From: Anita Gardner <Anita.Gardner@arun.gov.uk>
Sent: 09 October 2020 18:51
To: Planning.Responses <Planning.Responses@arun.gov.uk>
Subject: FW: LU/247/20/PL - 57 River Road, Littlehampton

From: Carl Gulland [REDACTED]
Sent: 09 October 2020 18:31
To: Anita Gardner <Anita.Gardner@arun.gov.uk>
[REDACTED] Geoffrey Murray [REDACTED]
Subject: Re: LU/247/20/PL - 57 River Road, Littlehampton

1908-P-305 North West Elevation - we have seen the correspondence from the owner of the adjacent property at 47 River Road and the concern that the view along the river is partially reduced by the massing of the proposal. It's worth noting that:

DRAWING NO: 1908_P_200

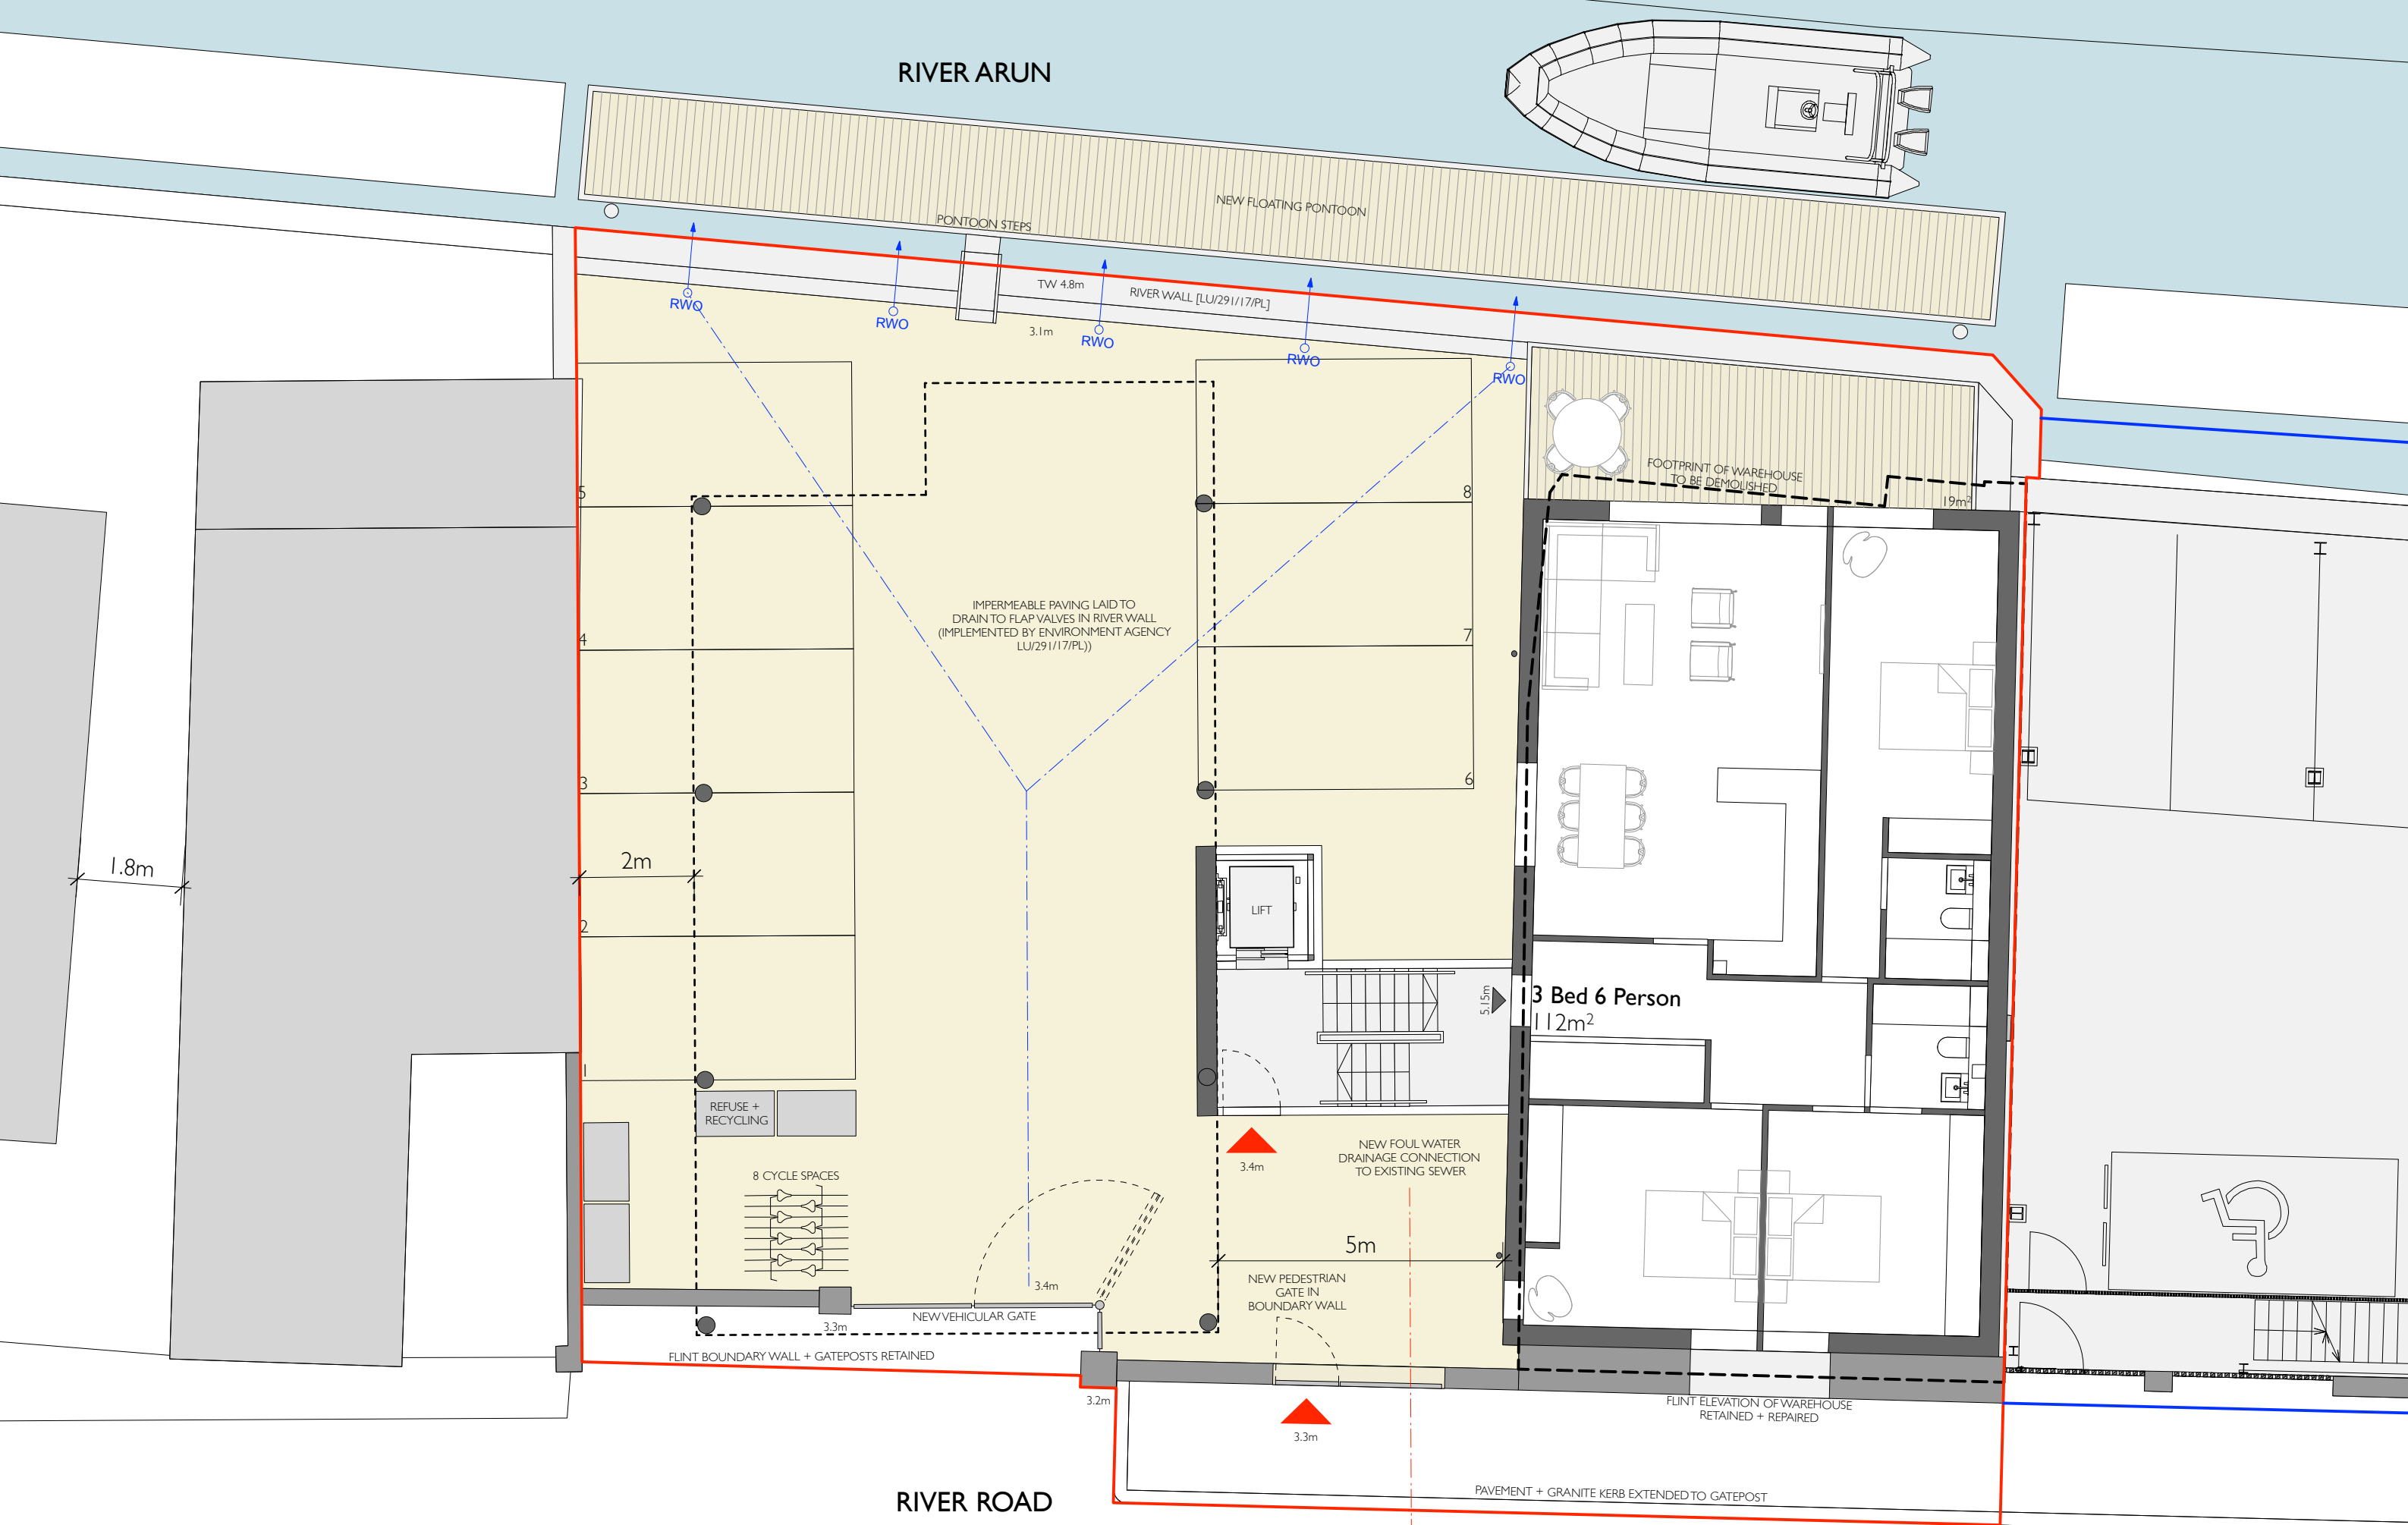
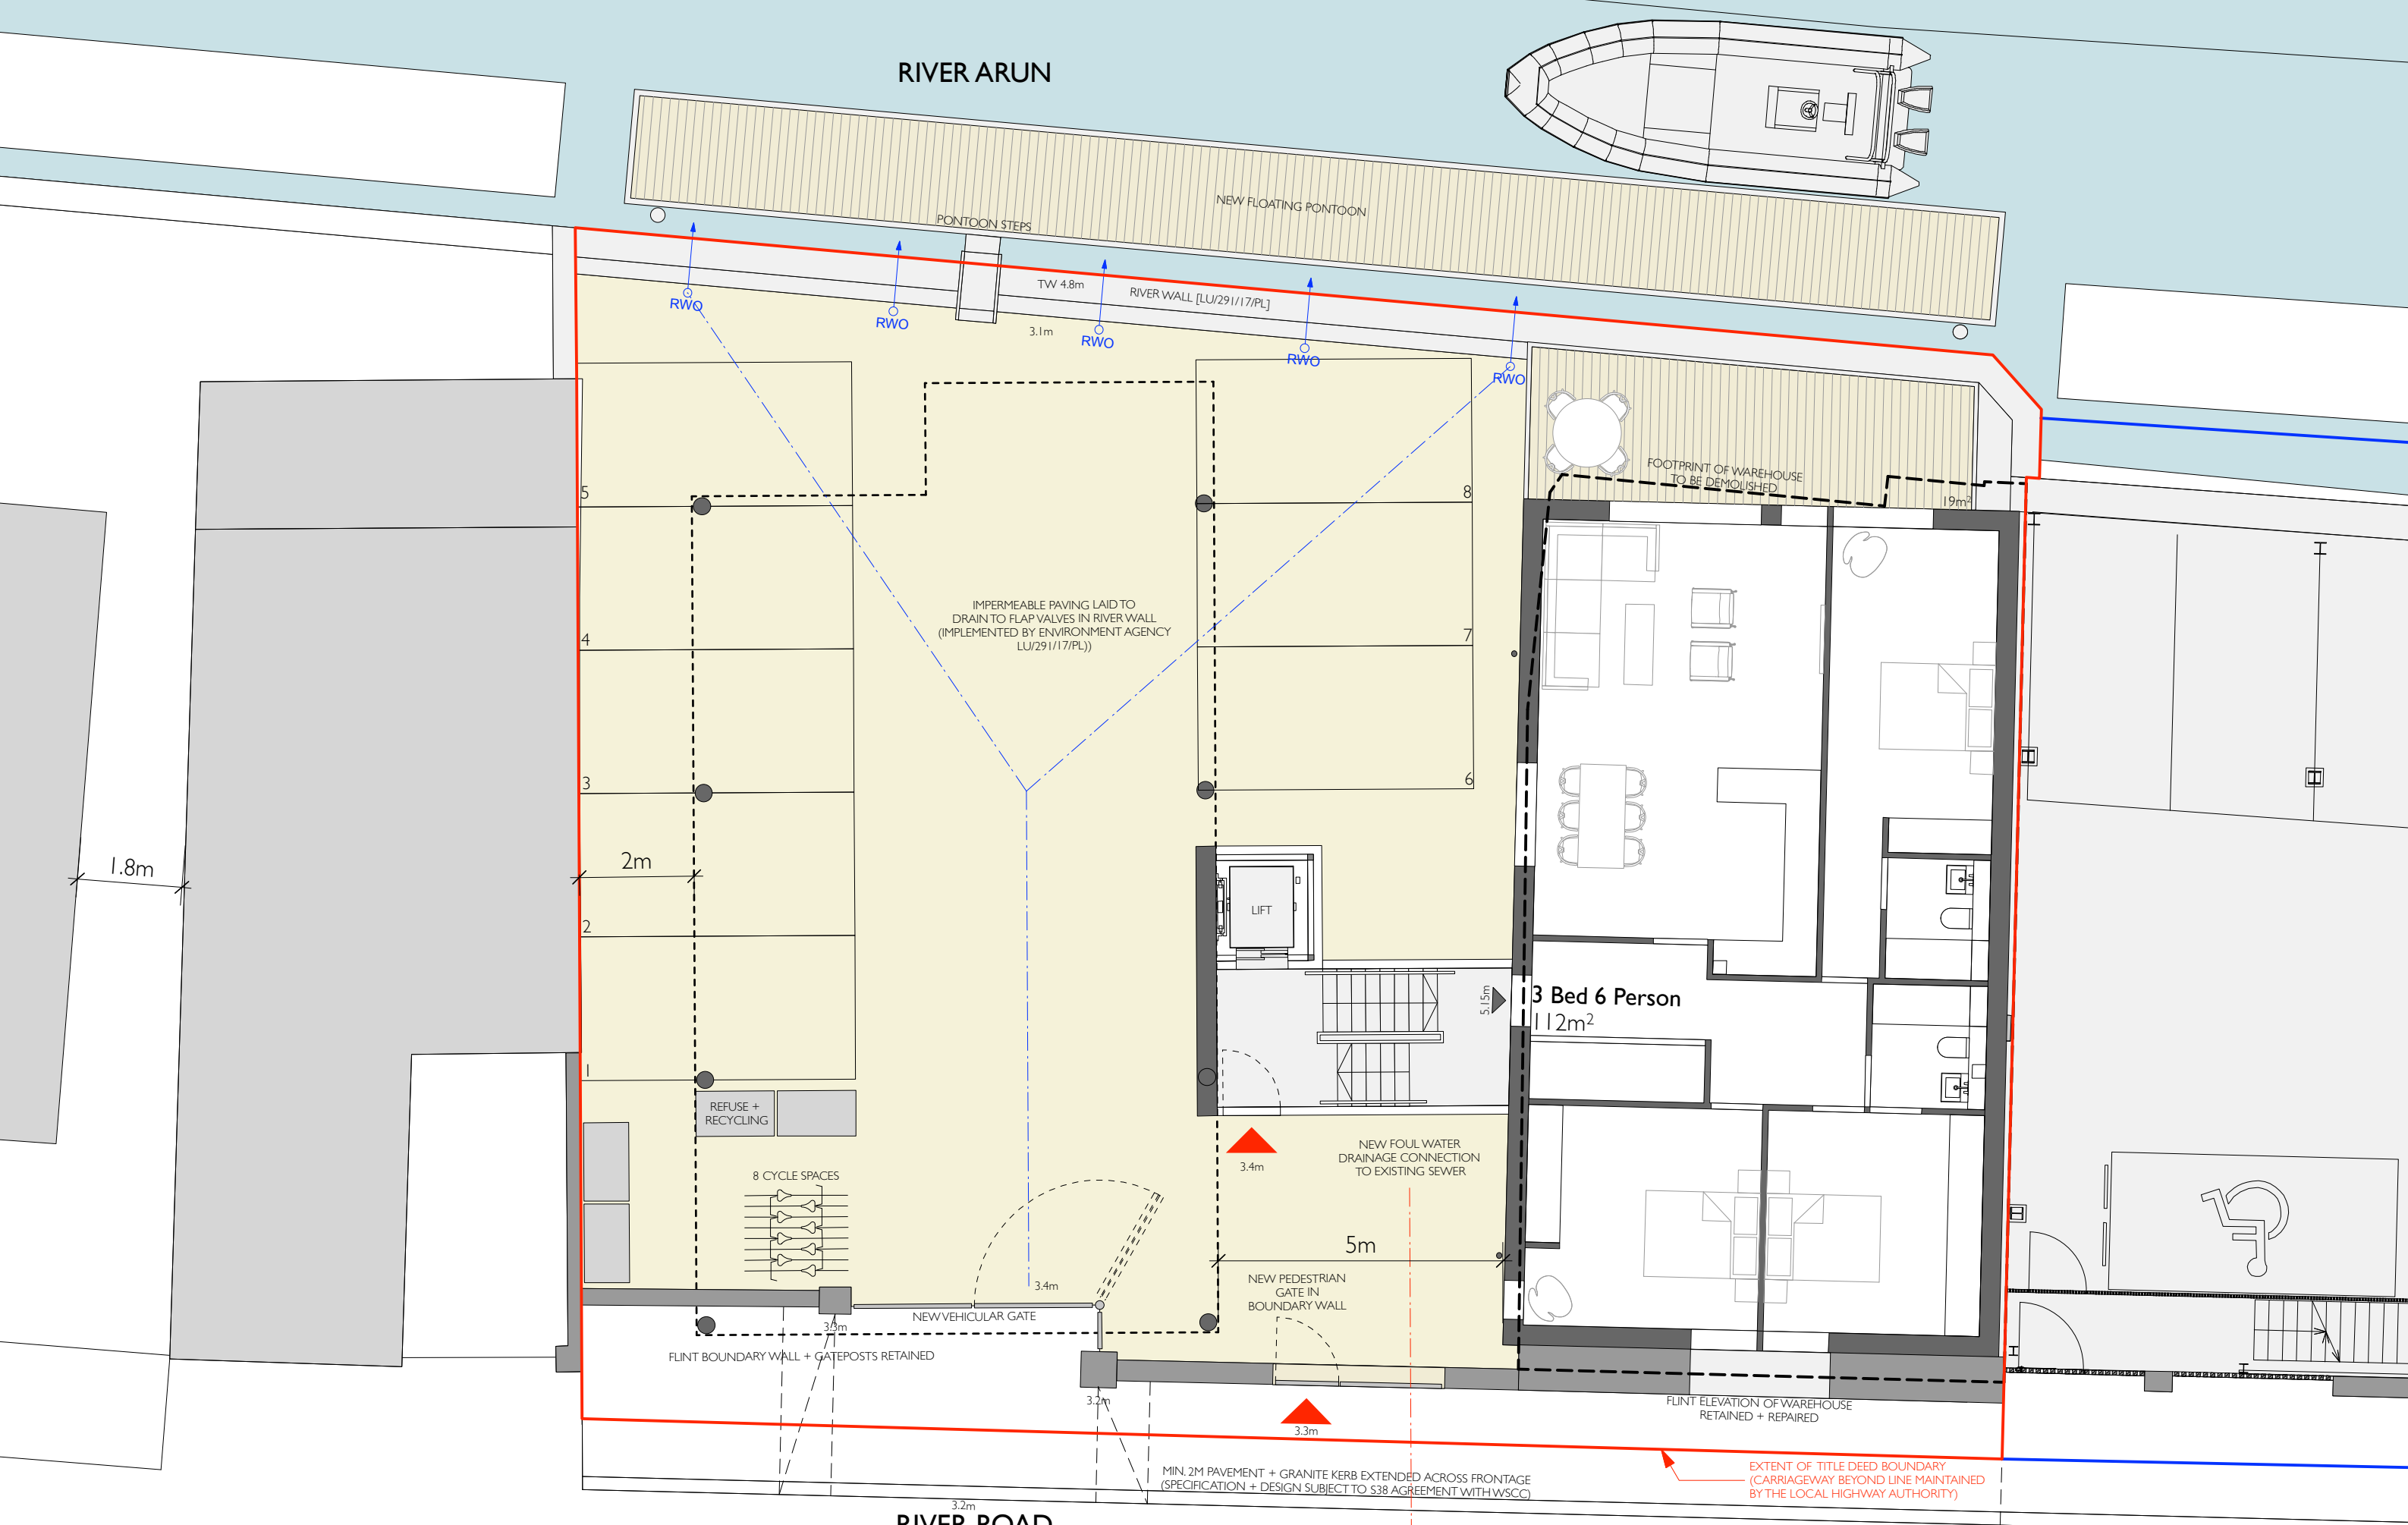
On a final point with regard to the pontoon. The owner of 49 River Road has suggested that **shortening the pontoon** would reduce the risk of trespassers having a passage along to other pontoons. This hadn't occurred to us as being a significant issue as there is only secure private access to all the pontoons along this stretch of river but we are happy to reduce the length of the pontoon by 1.2m/4ft to accommodate this concern.

DRAWING NO: 1908_P_304

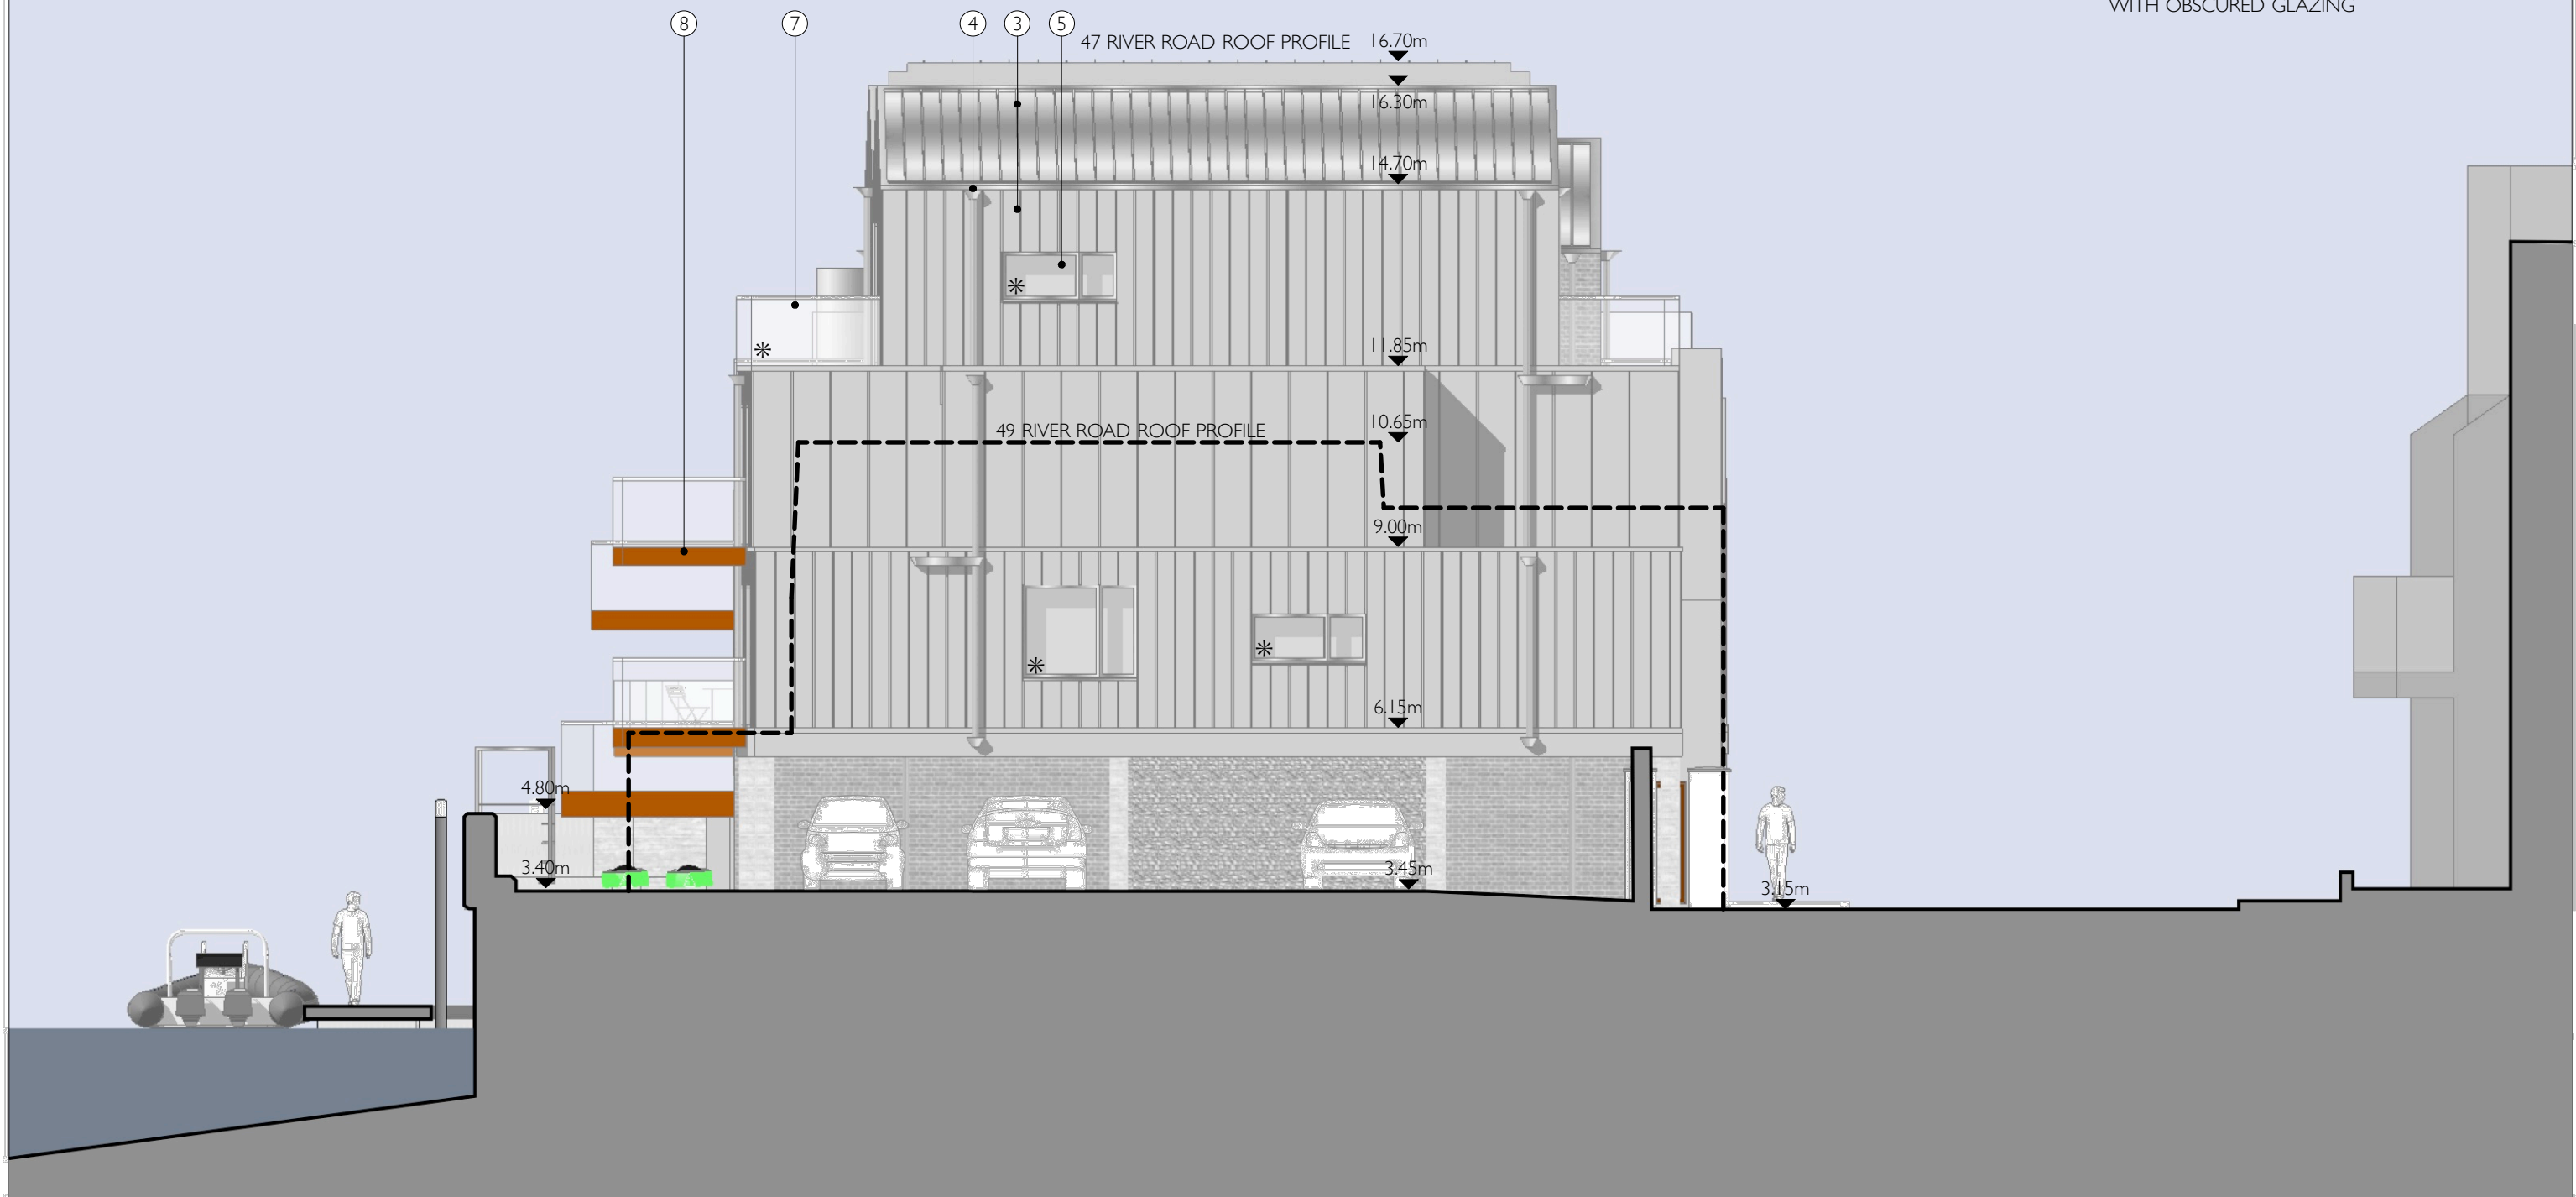
1908-P-304 South East Elevation:

- There are secondary windows (bathroom and kitchen) in this elevation which we are proposing to be obscured glazing to maintain privacy to 49 River Road.
- Similarly we are proposing an obscured glass side panel to the balustrade of the top floor balcony on the river side recognising the position of the first floor terrace and rooflights of 49 River Road.

We have seen the correspondence from the owner of 49 River Road and feel these appropriately address his main concerns regarding overlooking and privacy. His other concerns are understandable and mainly ones that we would seek to agree and address during construction (eg. rubber kerbs in parking bays to prevent cars impacting his terrace wall). The issues regarding **access to the floating pontoon** do need clarification:
